TfNSW Reference: SYD25/00508/01
DPHI Reference: SSD-77260958

**ADVICE ON EIS FOR HOTEL, COMMERCIAL OFFICE PREMISES AND RESIDENTIAL APARTMENTS
2-4 BURLEIGH STREET AND 20-24 RAILWAY PARADE, BURWOOD**

TAB A – TfNSW advisory comments

1 BASEMENT LEVEL 1 - HOTEL/ COMMERCIAL PARKING
1:200

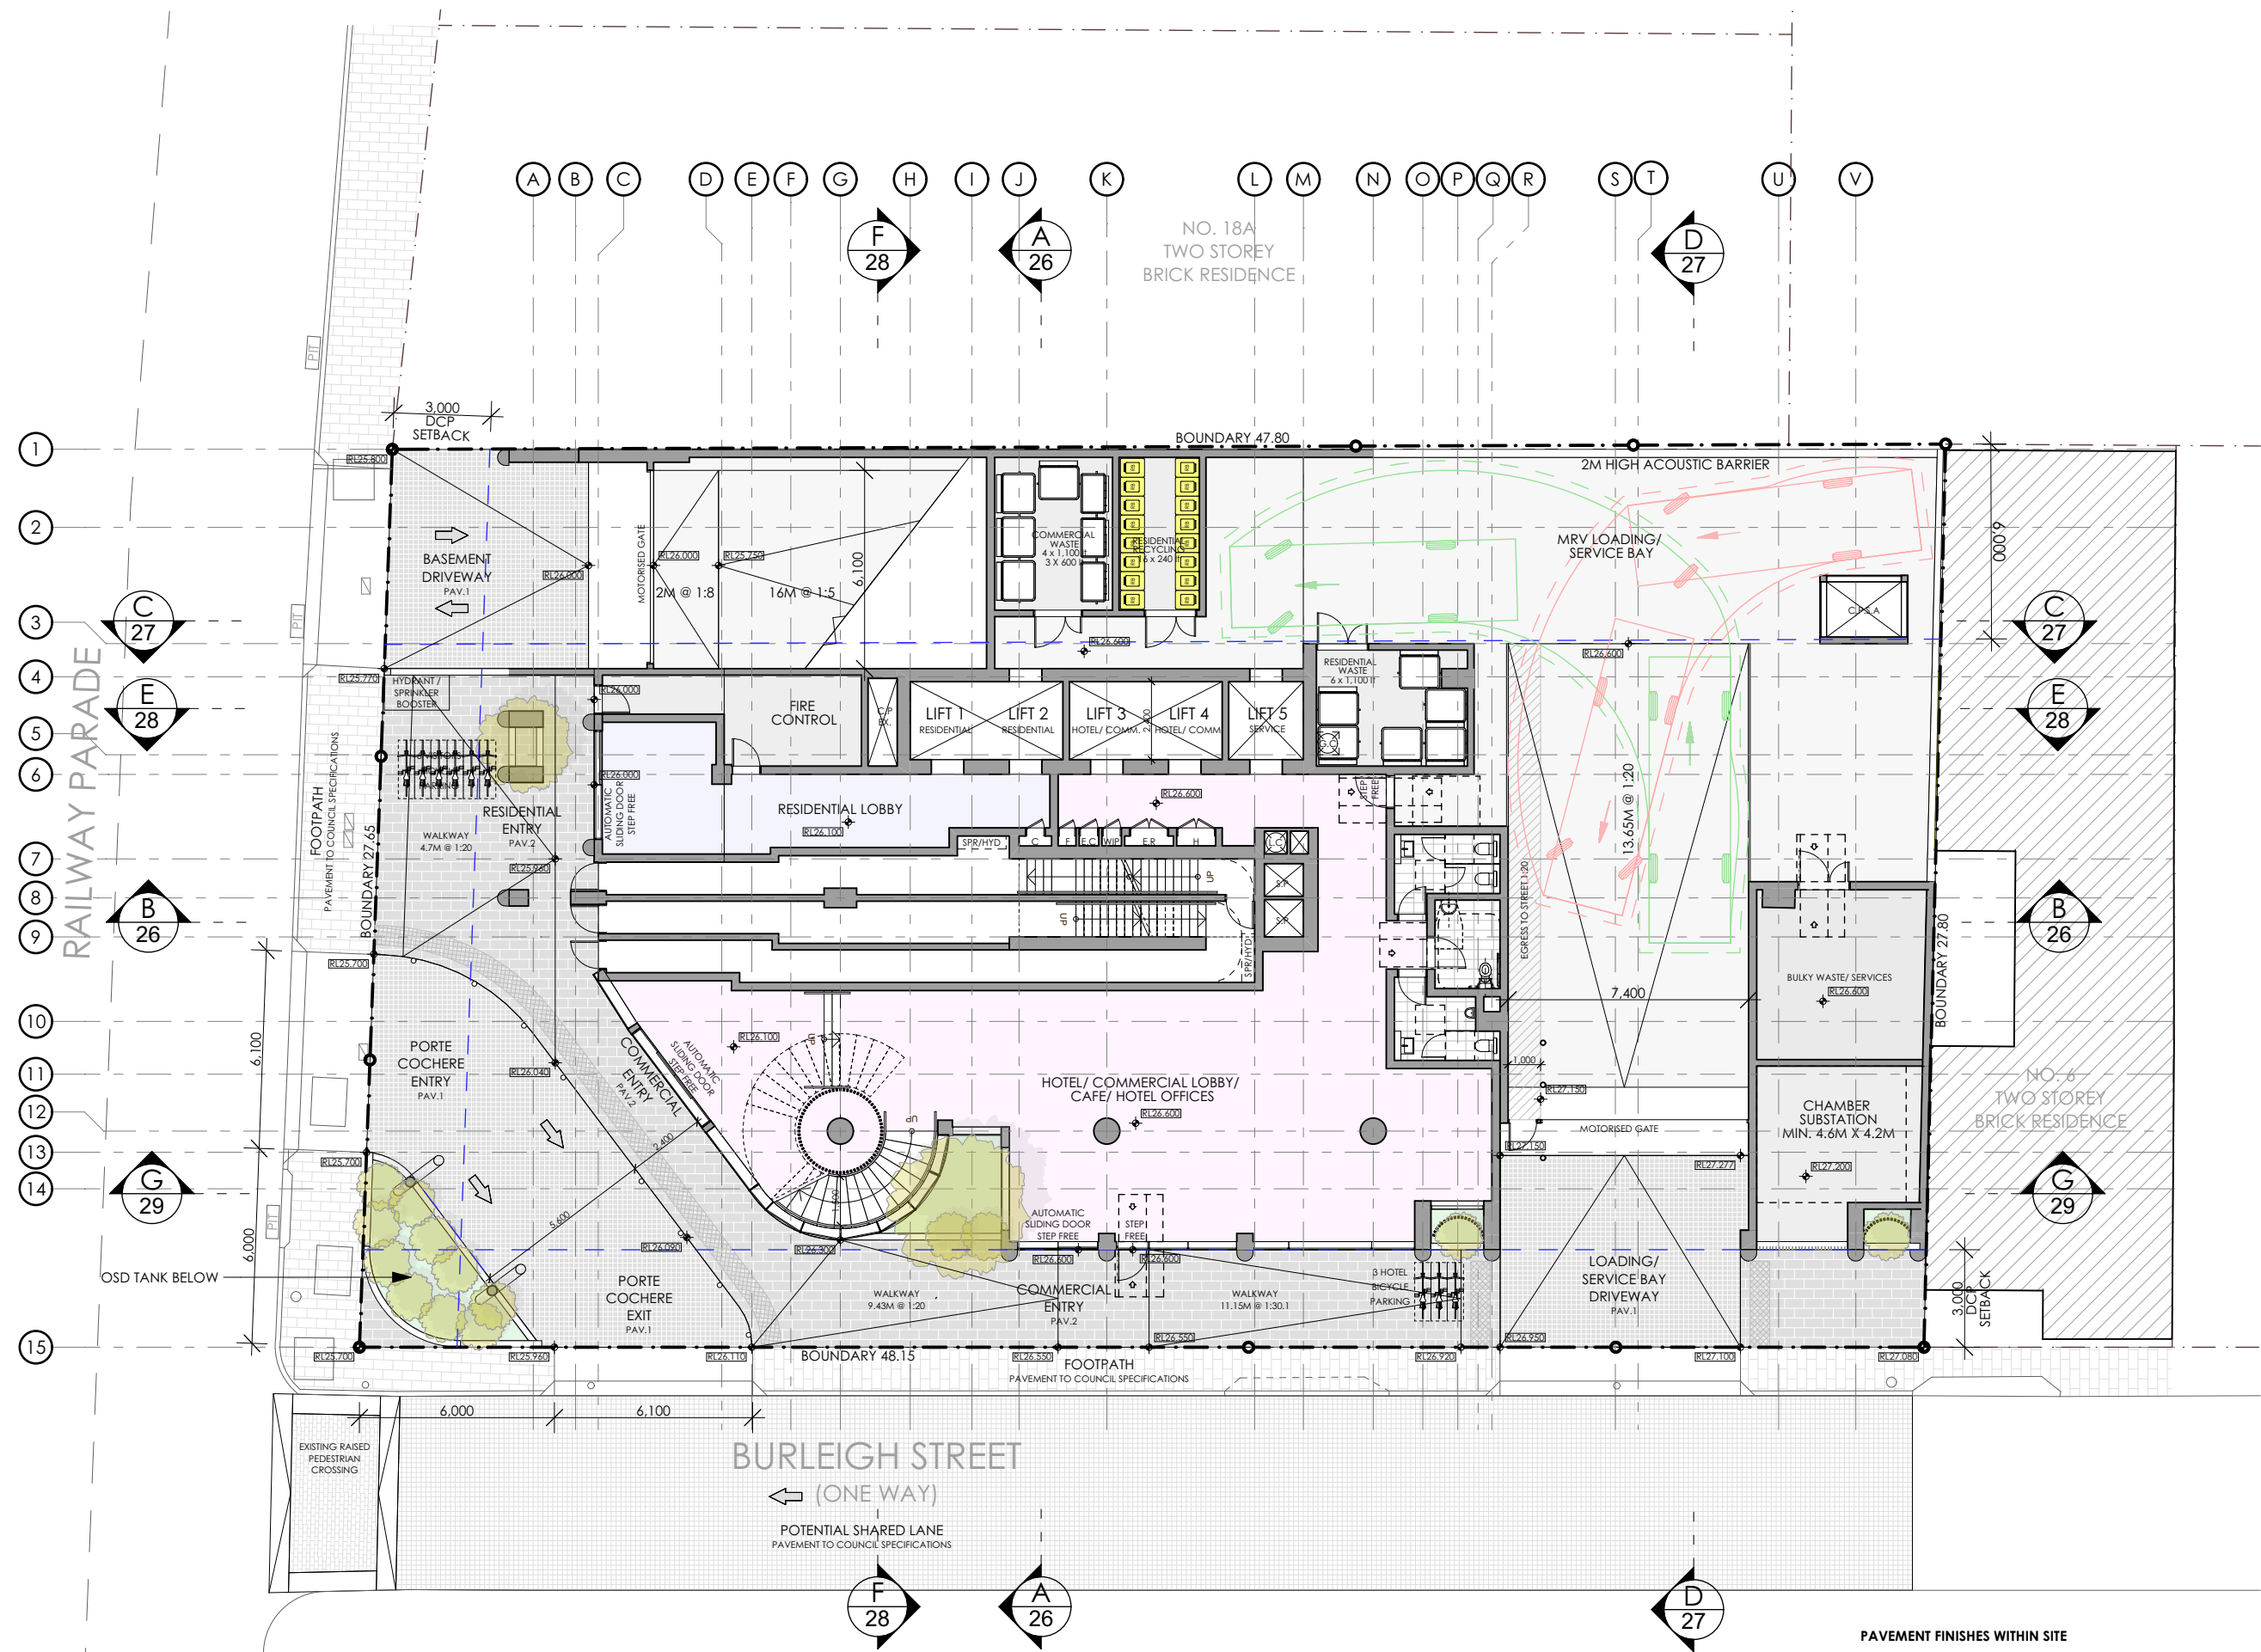
The site is to accommodate the delivery of trucks where queues may extend out to Railway Parade (**classified regional road**).

The operational Plan of Management (**PoM**) of the development shall ensure that deliveries are organised outside of transport peak periods (Monday to Friday 0700-0930 and 1600-1930) and any other management strategies to ensure that road safety and efficient transport operations is maintained.

1 GROUND FLOOR
1:200

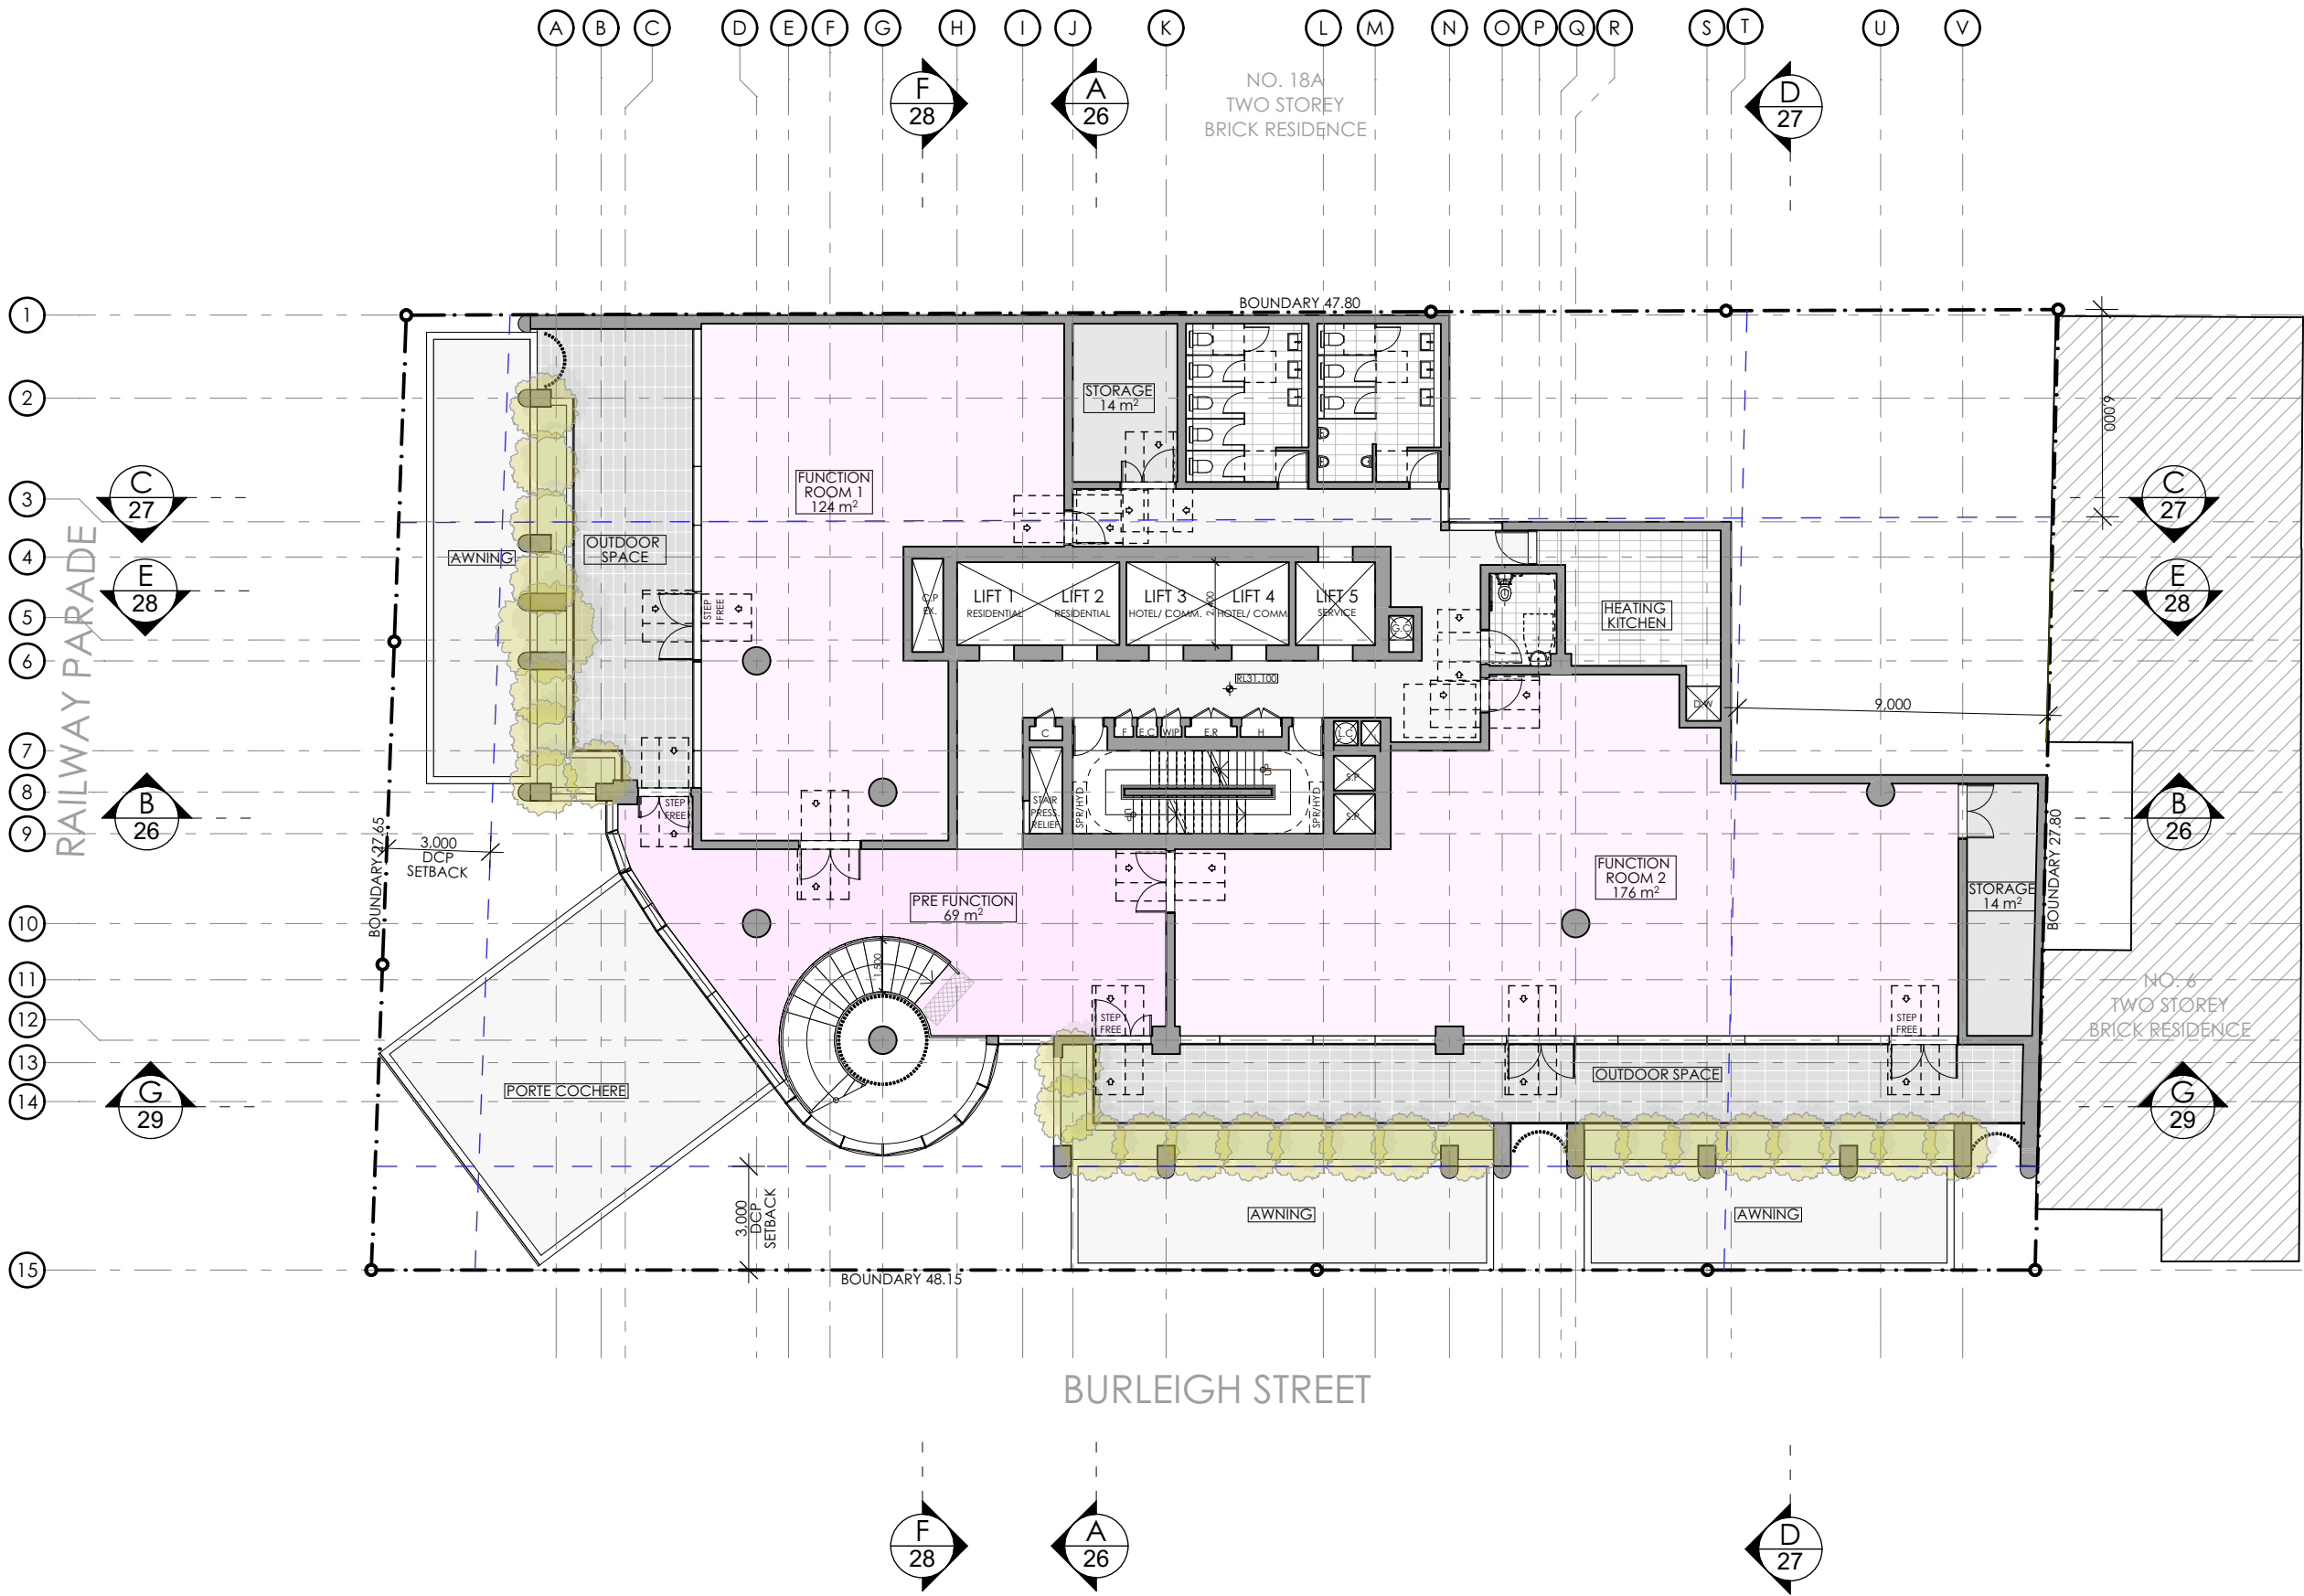
The proposal is expected to generate a peak pedestrian activity of approximately 135 pedestrian trips per hour, which is expected to compound the existing ad hoc pedestrian movements that occur across Railway Parade.

TfNSW notes that access modifications are proposed to Railway Parade (**classified regional road**), with various civil works and stormwater works proposed.

A pedestrian Road Safety Audit shall be undertaken for the existing situation to identify current deficiencies along Railway Parade in the vicinity of the proposed development and any potential deficiencies identified which may arise from the development that require mitigation shall be implemented by the Applicant, subject to the satisfaction of the relevant Road Authority.

As part of any Planning Approval issued, the Applicant should be conditioned to obtain TfNSW concurrence under section 138 of the *Roads Act, 1993* for any civil works on Railway Parade.
